Arun Civic Centre
Maltravers Road
Littlehampton
West Sussex
BN17 5LF

10 November 2020

Our Ref: LU/276/20/HH

With regards to the discrepancy between the proposed elevations and the proposed floor plans submitted, these plans must match so it is completely clear what you are applying for and if successful what the approval relates to. There cannot be a discrepancy in the plans, they must be amended to show the correct measurements on both.

EXISTING FLOOR PLANS

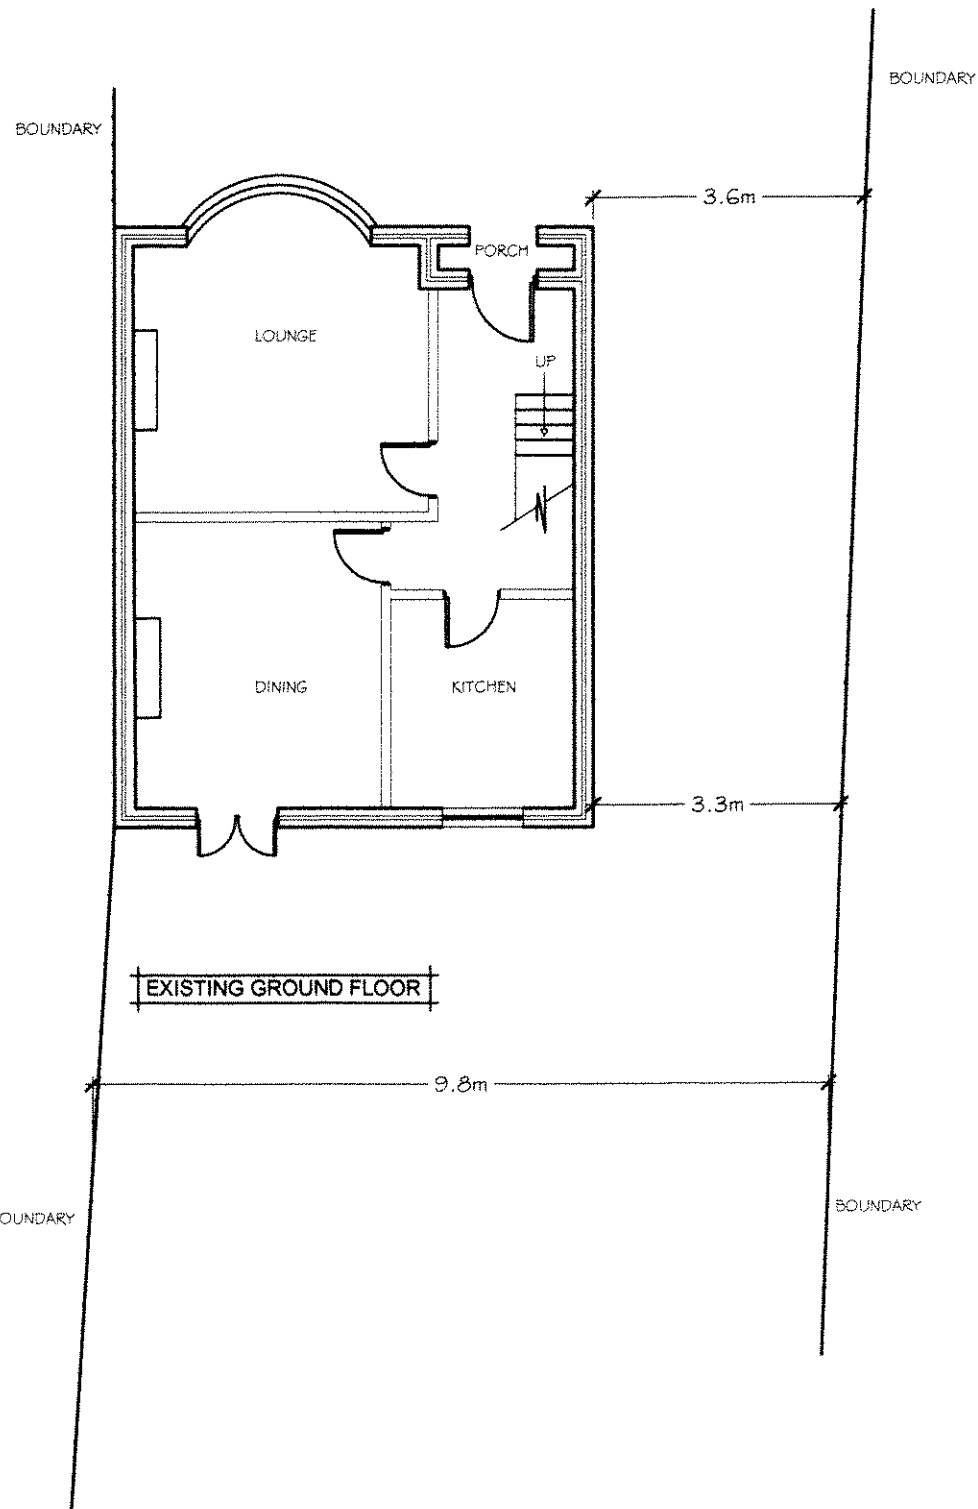
from the boundaries. Whilst you have included the distances of the existing property to the boundaries on the existing floor plan this does not clarify how far the proposed extension will be. Please provide this information.

DRAWING
BLOCK PLAN

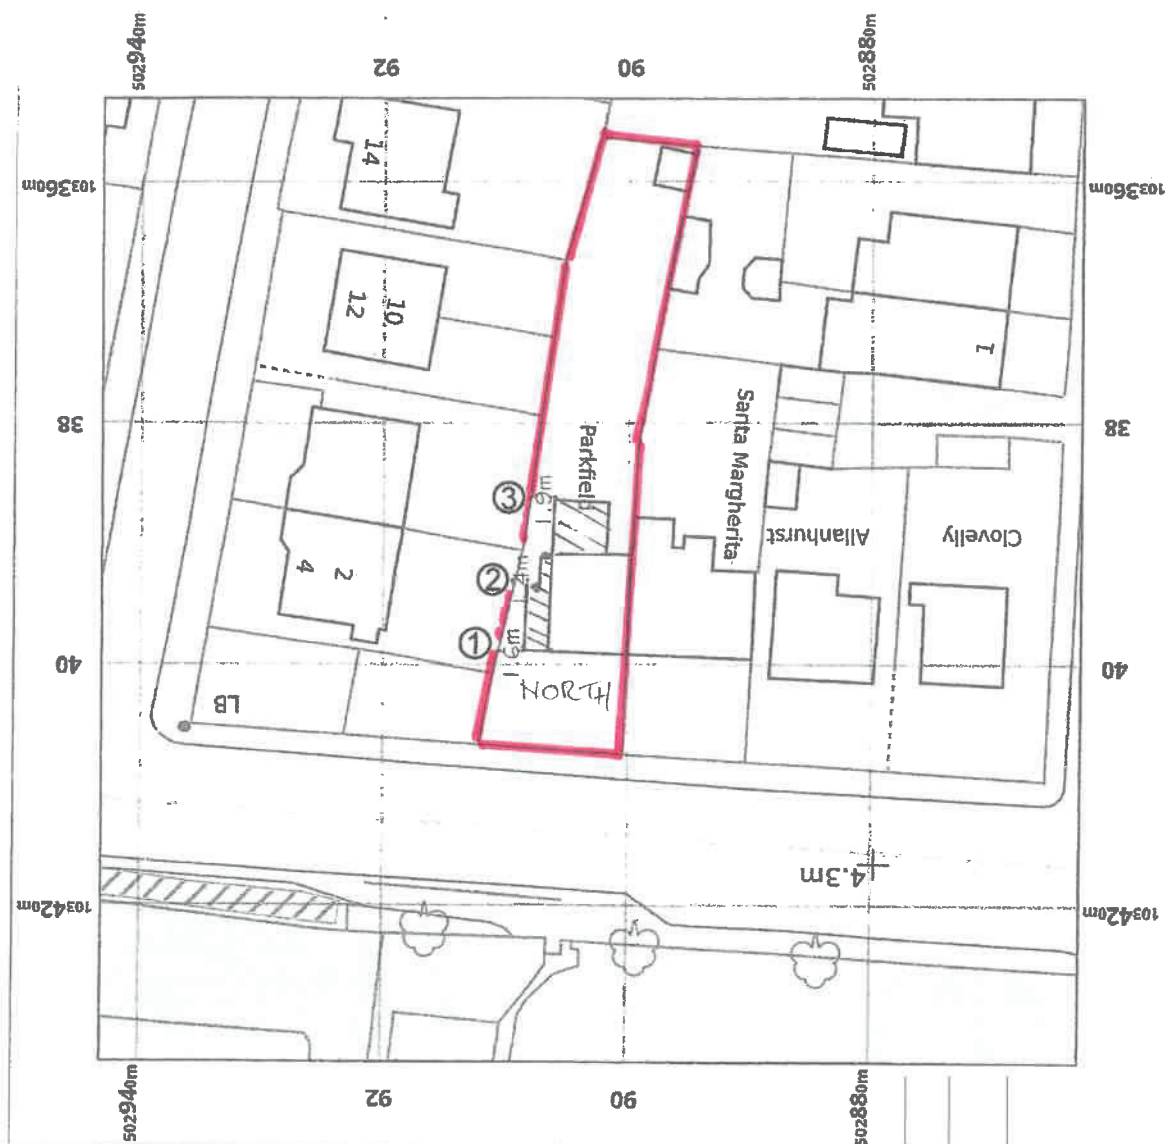
It is a local validation requirement that the written dimensions of the distances of the proposal from the boundaries are shown on the block plan so that it is clear how far the proposed extension is from the side and rear boundaries. The purpose of requiring this is so that anyone with an interest in the development can be clear how far the proposal is
